**Planning & Building Control Service  
Development Management  
Westgate Plaza  
PO Box 603, Barnsley, S70 9FE  
Head of Service: Joe Jenkinson**

My Ref: 2021/1089 and 2021/1090  
Your Ref:  
Date: 21st January 2022  
Enquiries Stacey White  
Direct Dial: 01226 772604  
E-Mail: staceywhite@barnsley.gov.uk

**PLANNING APPLICATIONS:** 2021/1089 & 2021/1090  
**LOCATION:** MU1 site, Land South of Barugh Green Road, Barnsley

# VIEWPOINT N

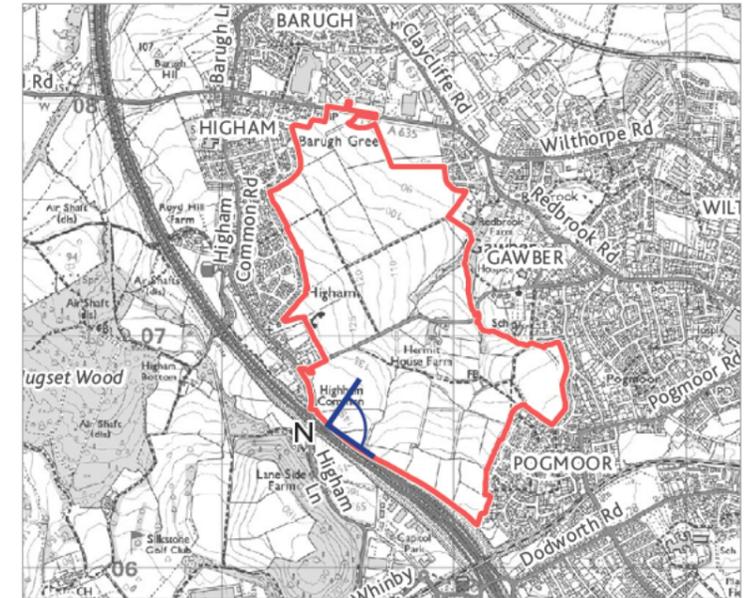
Xanthe has identified several issues with the assessment conclusions in terms of impacts on views into the site from near-middle distance which are considered to be transformative. Extensive middle-distance views from Mapplewell are not considered for example from Darton Lane, Swallow Hill Road, B6428, Hill End Road and Lidgett Road. Employment development will be 'perched' in the landscape across views and of considerable scale. The effects of the development from the motorway is also considered to be underassessed.
